HTE #: Bres2105-0057

HARNETT COUNTY HEALTH DEPARTMENT
ENVIRONMENTAL HEALTH
307 CORNELIUS HARNETT BOULEVARD
LILLINGTON, NC 27546

EXISTING SEPTIC SYSTEM INSPECTION

Purpose of Inspection: Addition of 14' x 40 storage shed

NAVAHO TRAIL
 60' PUBLIC RIGHT OF WAY
FOUNDATION SURVEY

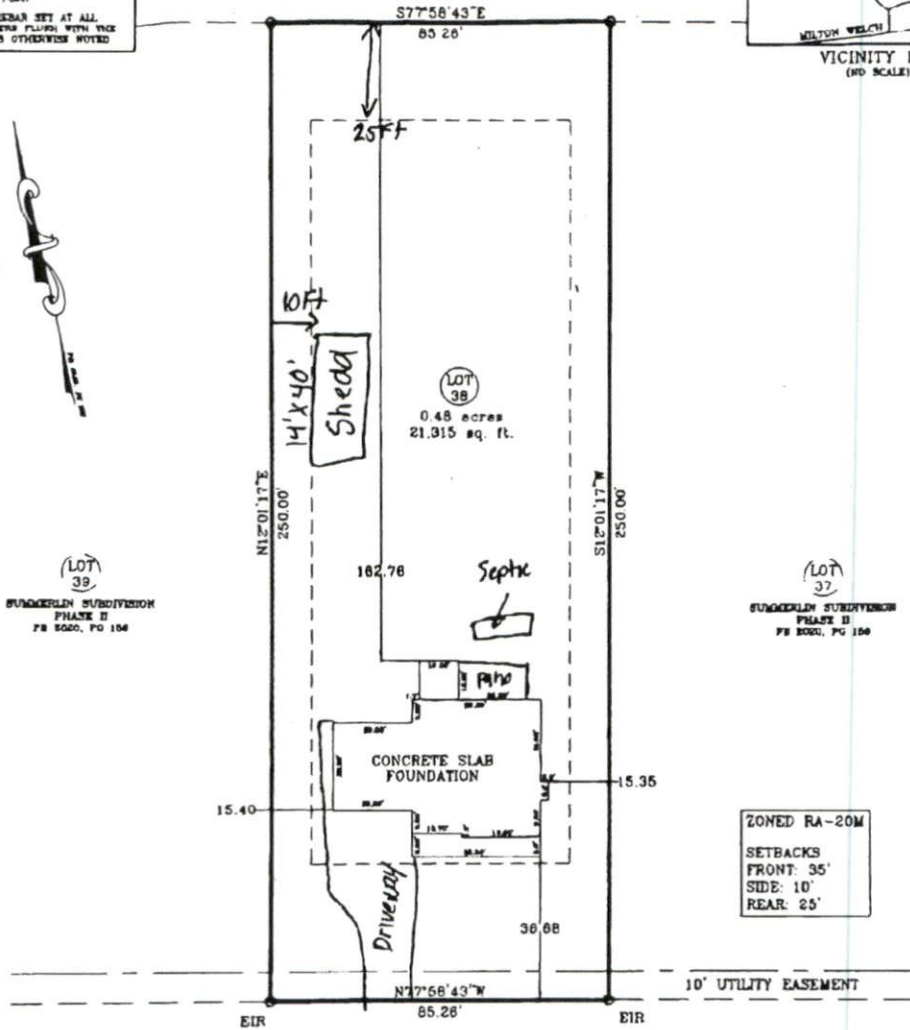
Shed must be 5' off of any part of septic system

**BUILDING MUST BE 5' FROM ANY PART OF SEPTIC SYSTEM
DO NOT DRIVE OR PARK ON SEPTIC SYSTEM**
